MODIFICATION REQUEST:

132-138 Killeaton Street, St Ives

***MP10_0057 MOD 6 – Modification to add
Pergolas to Blocks A, B & D***

Director General's
Environmental Assessment Report
Section 75W of the *Environmental Planning and
Assessment Act 1979*

BLOCK B ELEVATIONS

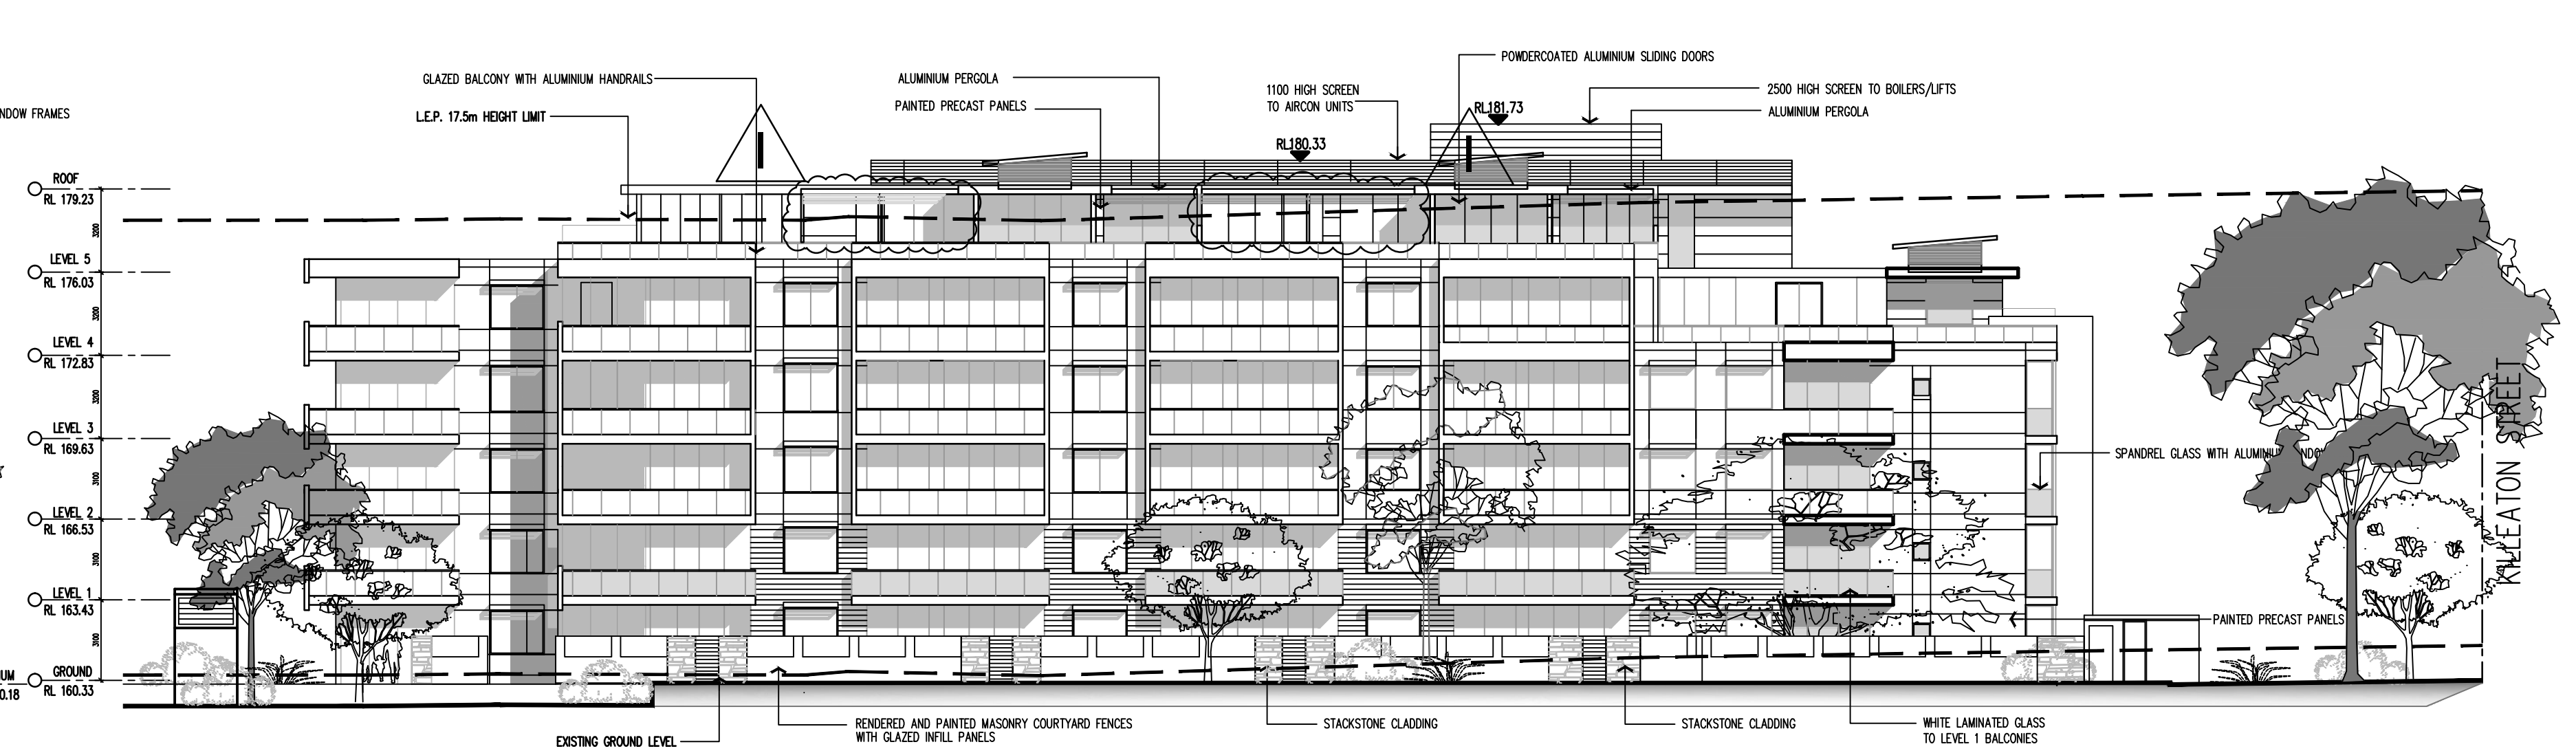
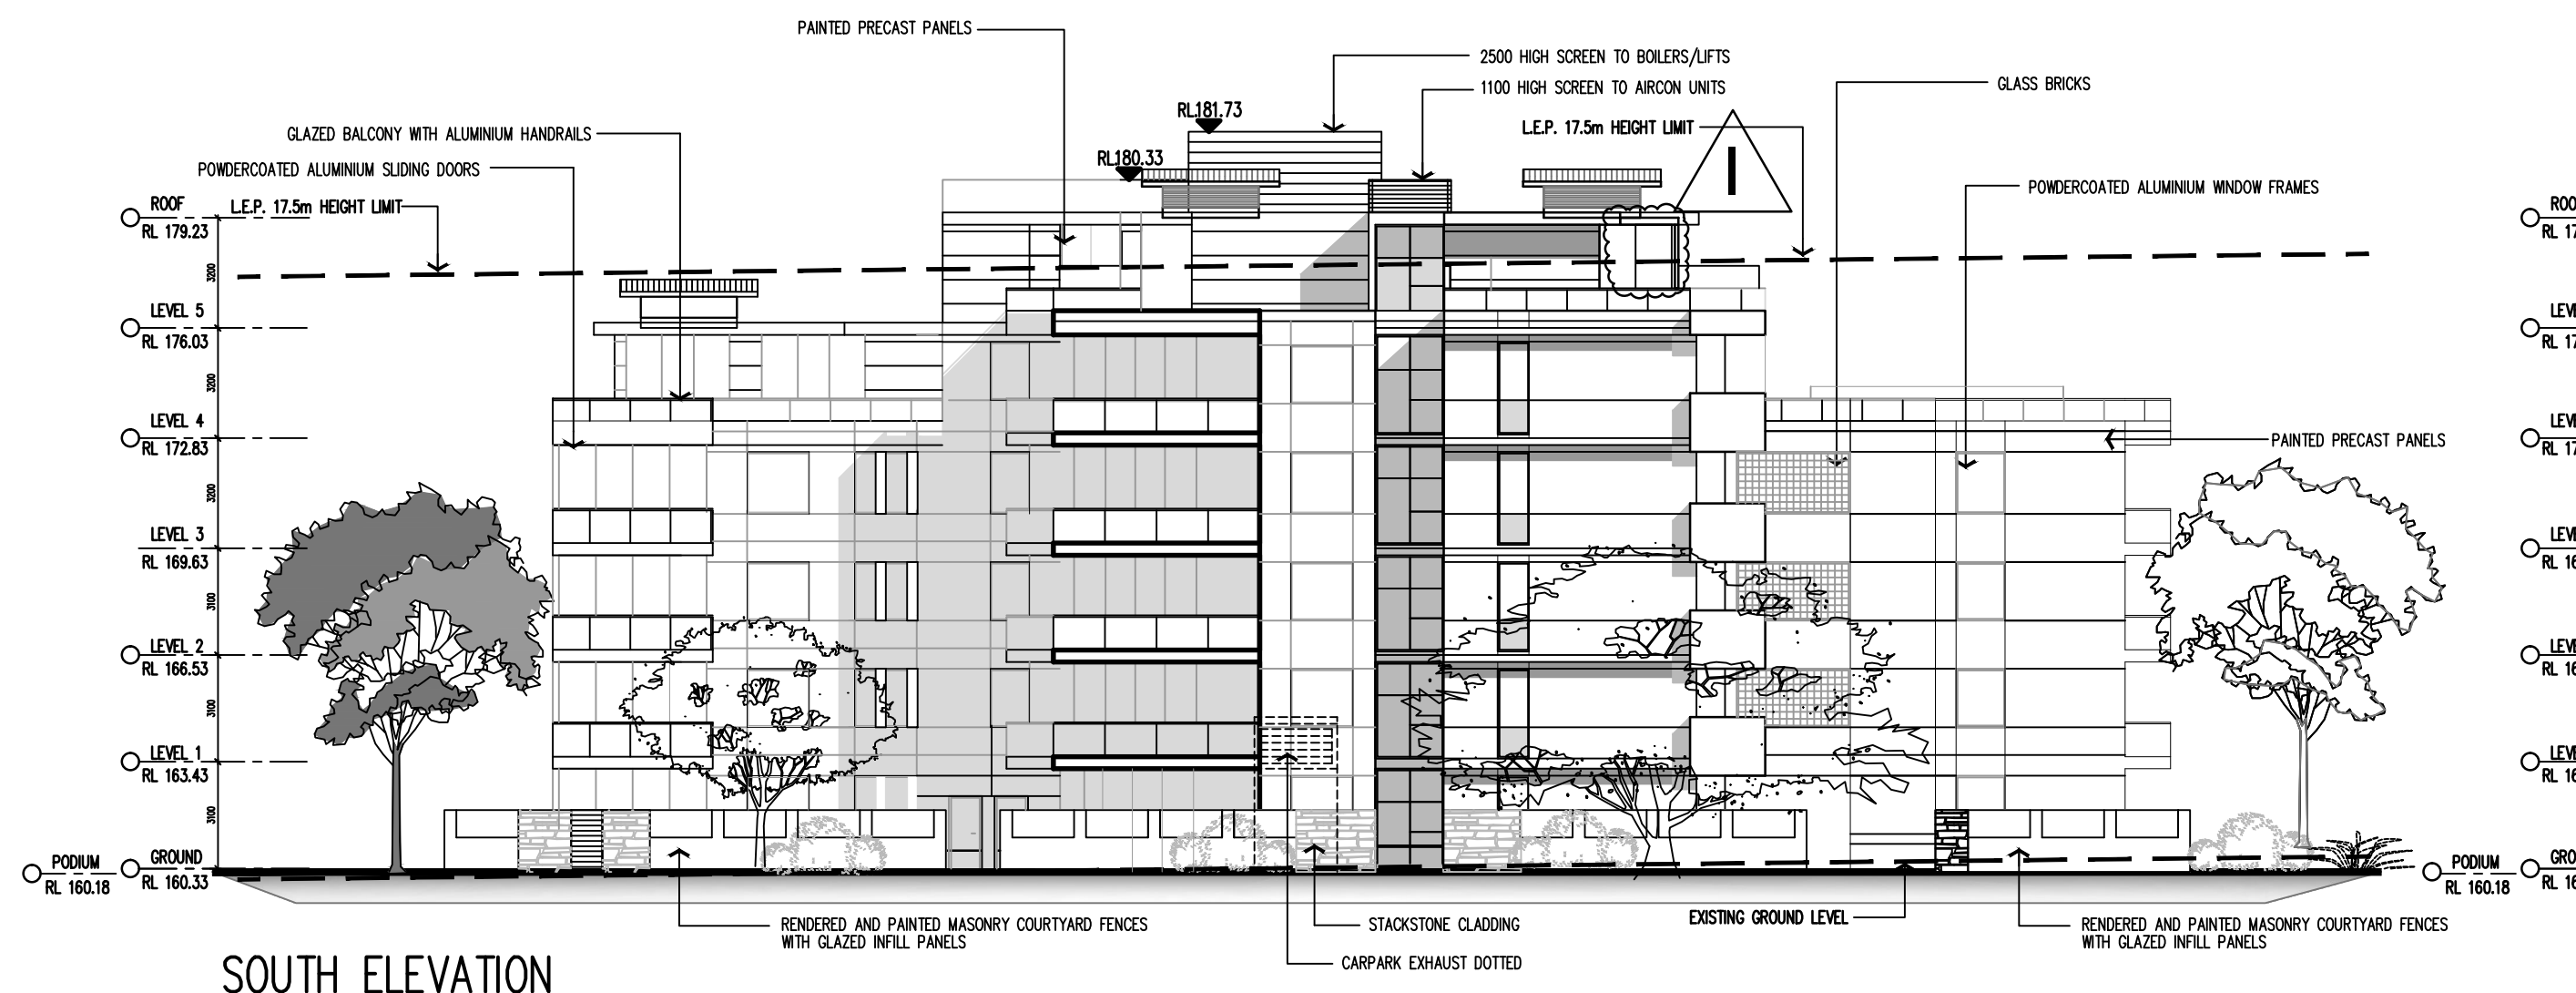
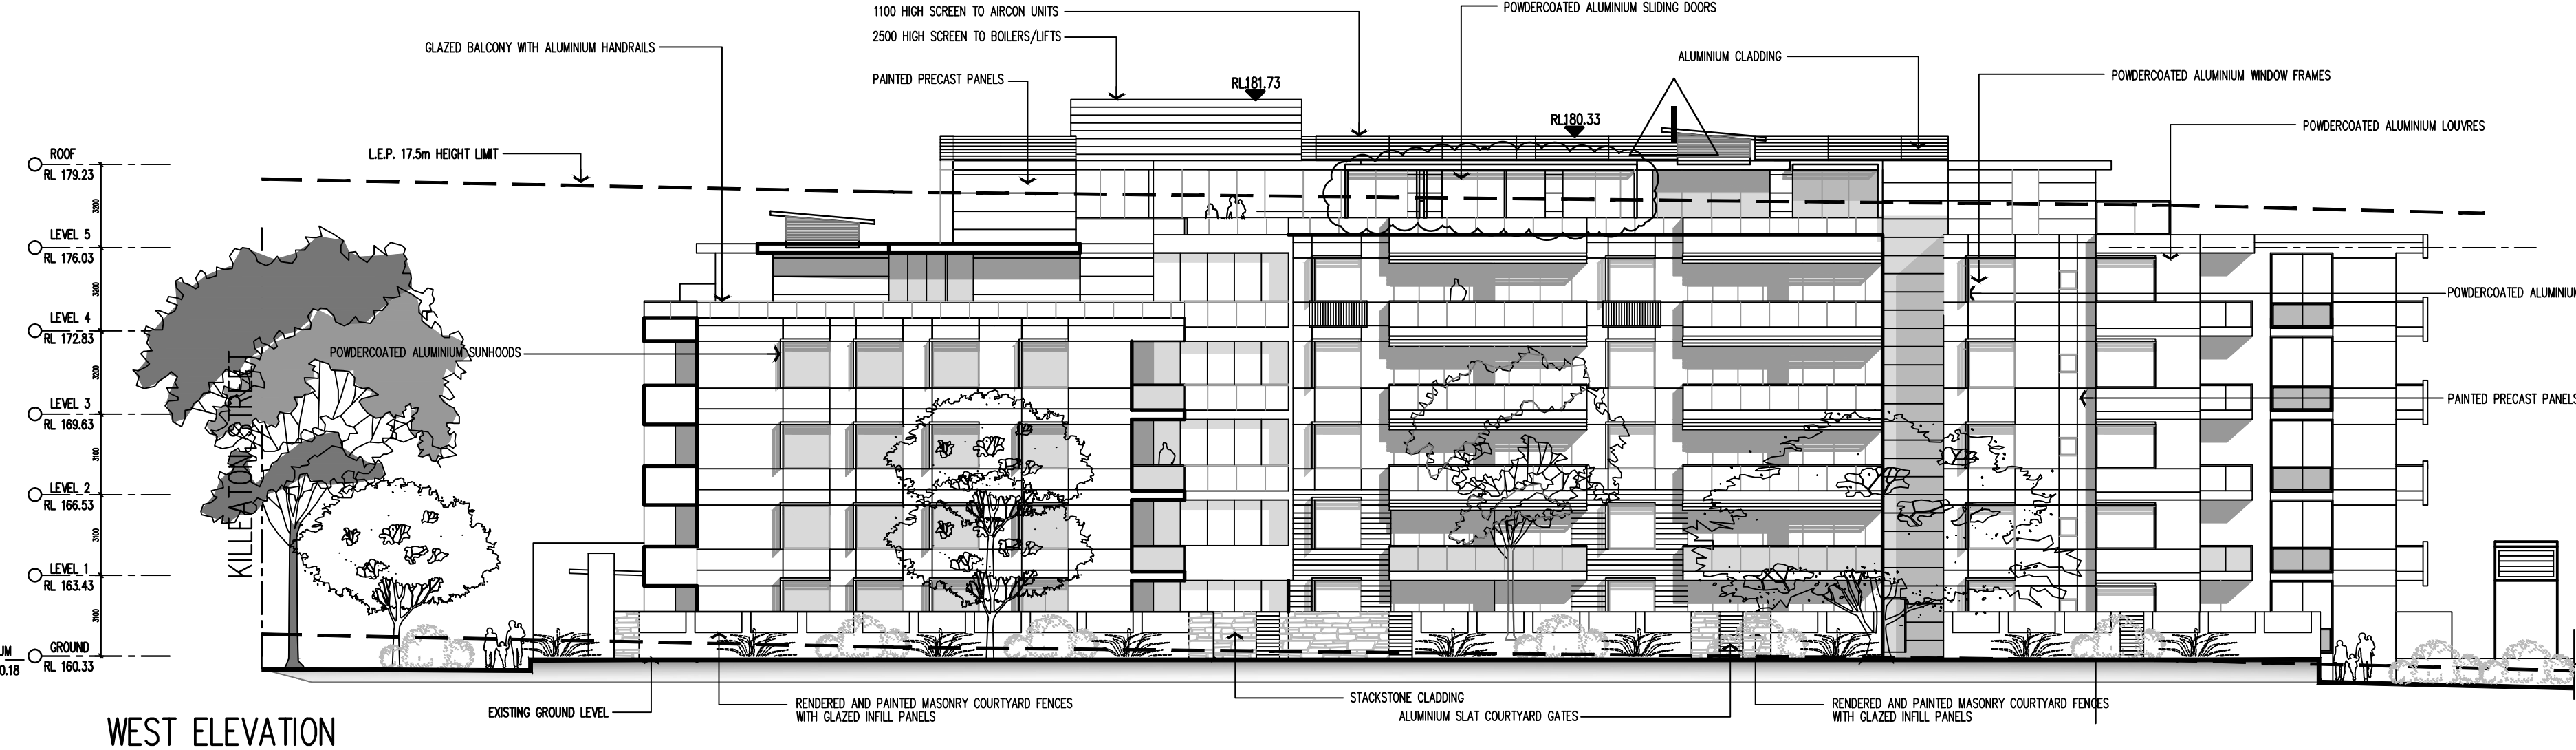
- Ku-ring-gai Local Environmental Plan No. 194 requires the top storey to be 60% of the floor below. Therefore, the top storey and associated ancillary structures are to be setback from the external edge of the building to recess the top storey and reduce the massing of the building at the uppermost level;
- pergola structures to the edge of the buildings are not supported as recessing of the top storey loses its design intent. It is recommended that pergola structures be setback, preferably 1.5m-2m where possible; and
- pergola structures must be of light weight material finish and open style to ensure the bulk, scale and design of the top storey remains relatively unchanged.

Ku-ring-gai Council (Council) did not support pergola structures being constructed to the edge of the building line as recessing of the top storey loses the building's design intent. Council advised that the top storey and associated ancillary structures such as pergolas be setback from the external edge of the building to recess the top storey and reduce the massing of the building at the uppermost level. Council recommended that pergola structures be setback, preferably 1.5m-2m.

- all pergola structures will be setback a minimum of 2 metres from the approved building line as shown in the amended plans.

The proponent responded to the Council's submission by submitting amended plans which shows all proposed pergolas being setback a minimum of 2 metres from the approved building line. The proponent has also acknowledged that the pergolas will be constructed of lightweight materials that will allow for visual transparency.
